Our Ref: DOC20/276841
Your Ref: MP05_0129 MOD 3

RE: Modification – Lakes Estate Residential Subdivision (MP 05_0129 MOD 3), Lot 10 DP1240161, North Boambee Valley, Coffs Harbour

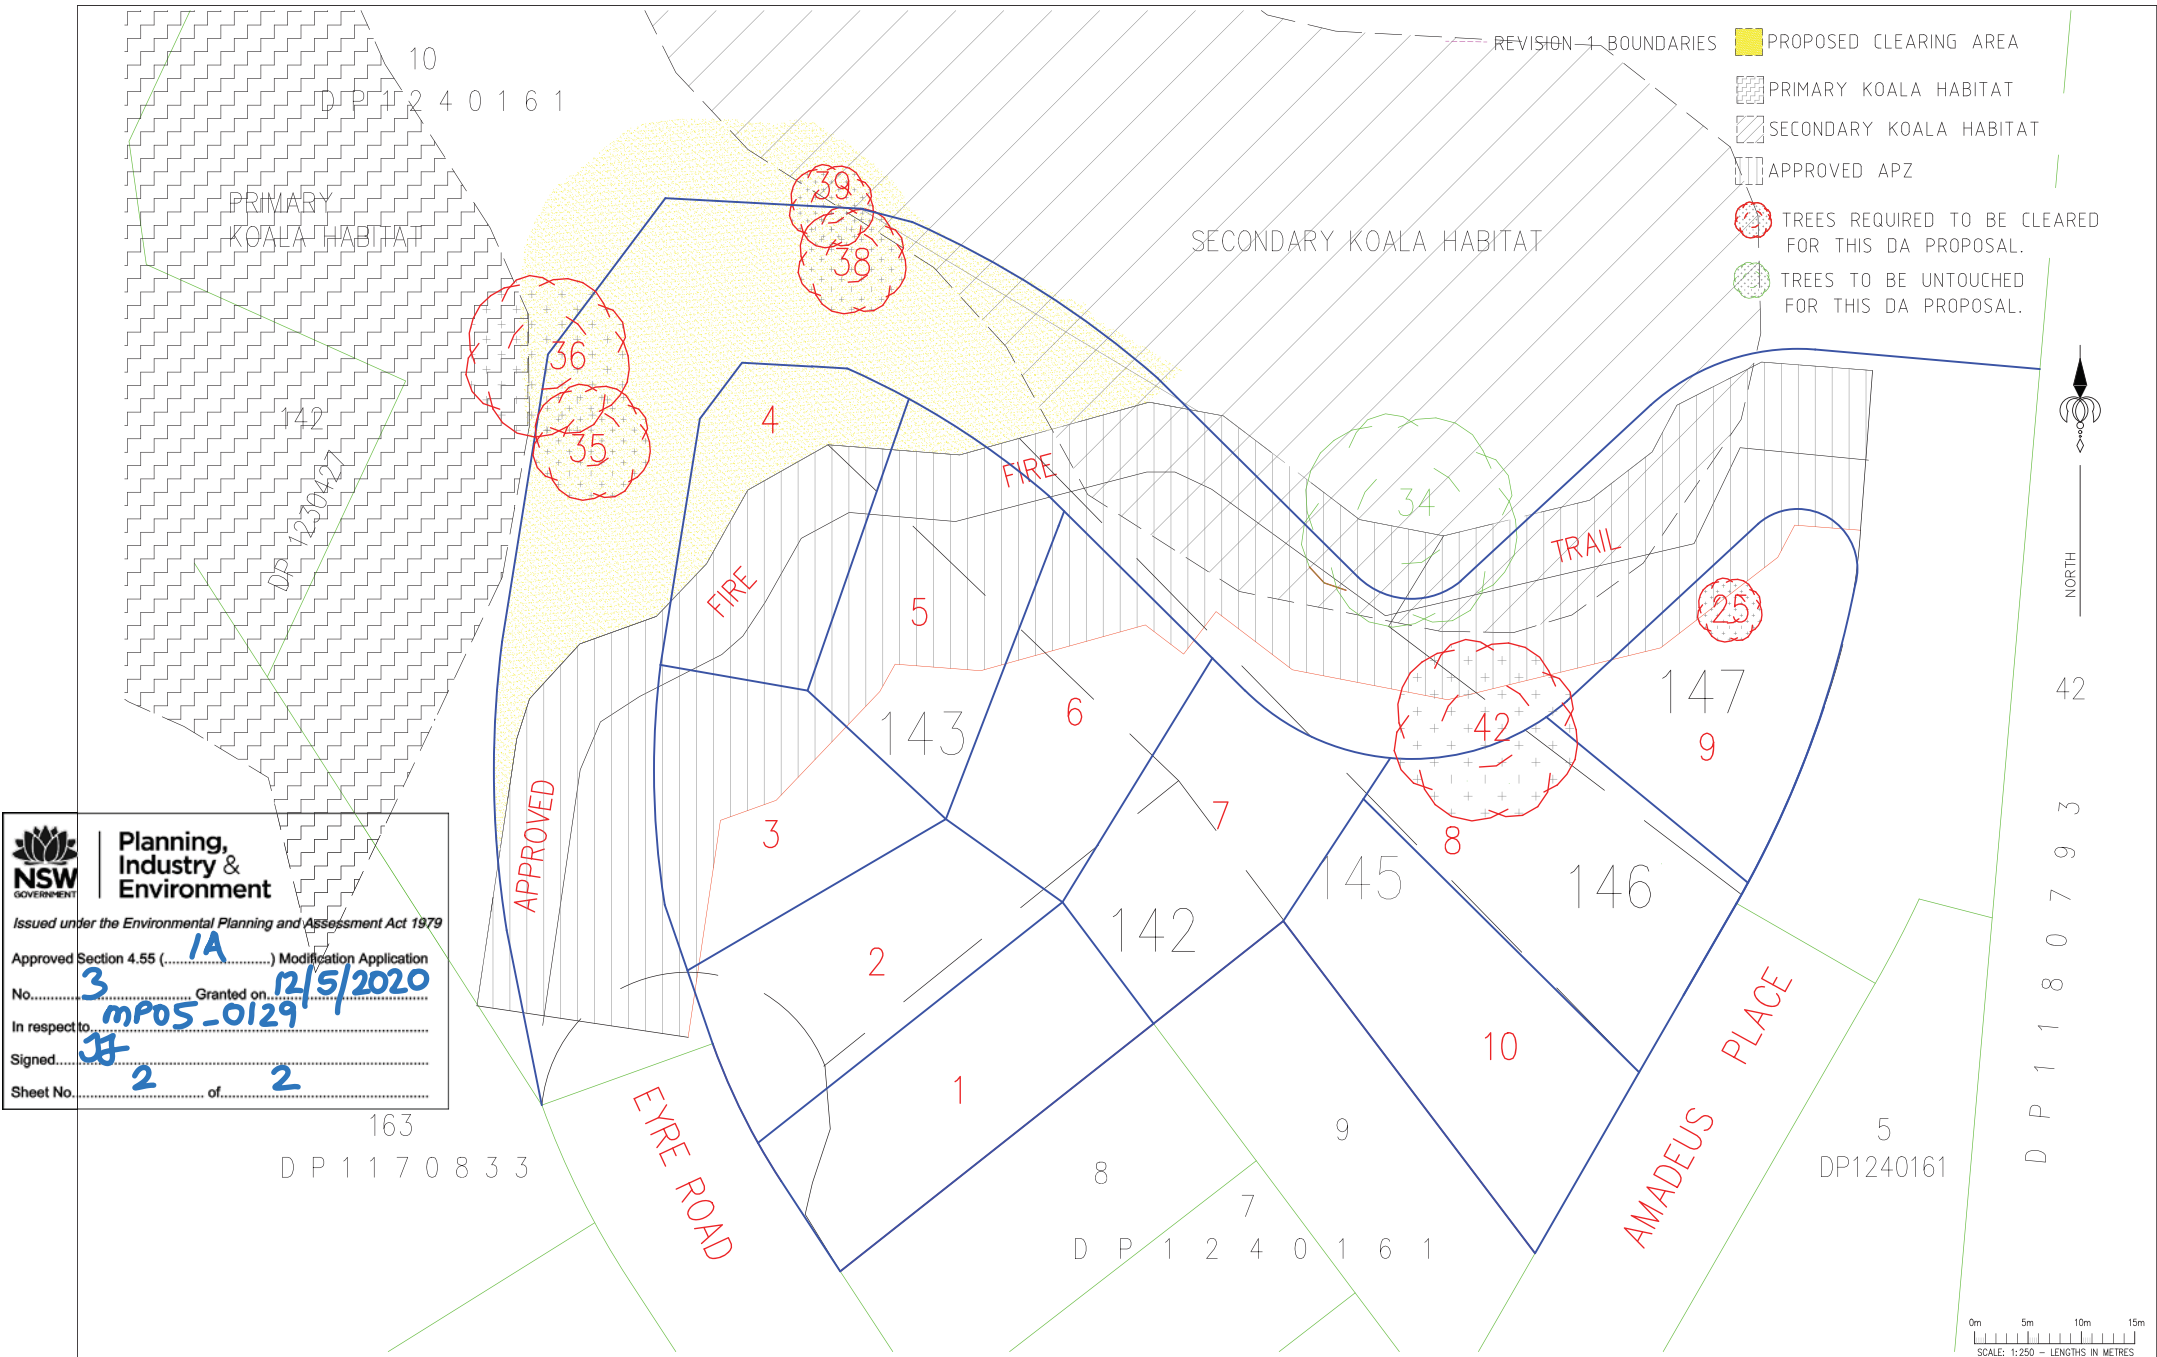
The BCD provided a response with recommendations to the Stage 3 modification in a letter dated 17 February 2020. We understand that the applicant has since amended the design of the public road to meet the NSW Rural Fire Service requirements, resulting in the retention of tree 37 (previously to be removed). The previous BCD recommendations dated 17 February 2020 have now been amended as set out below

1. The recommendations set out in Section 10 of the Ecological Assessment (Biodiversity Australia, October 2019) must be included as conditions of consent (with the exclusion of Tree 37 from Table 12 of recommendation 10.5).

2. The following must be included as conditions of consent:
 - a. The four koala food trees (*Eucalyptus microcorys*) proposed to be removed must be replaced by compensatory planting at a ratio of 1:5 in accordance with the Coffs Harbour KPOM and Section E1.2 of the Coffs Harbour City Council Development Control Plan. This will require 20 *Eucalyptus microcorys* koala food trees to be planted.

- b. The two *Acacia melanoxylon* trees proposed to be removed must be replaced by compensatory replacement planting at a ratio of 1:2 in accordance with Section E1.2 of the Coffs Harbour City Council Development Control Plan. This will require four *Acacia melanoxylon* trees to be planted.

- d. The proponent must apply to the Coffs Harbour City Council to have the hollow bearing tree (Tree No11) listed on the council's Significant Tree register. Evidence of the tree having been listed on the register must be provided to the certifying authority prior to the issuing of the construction certificate.
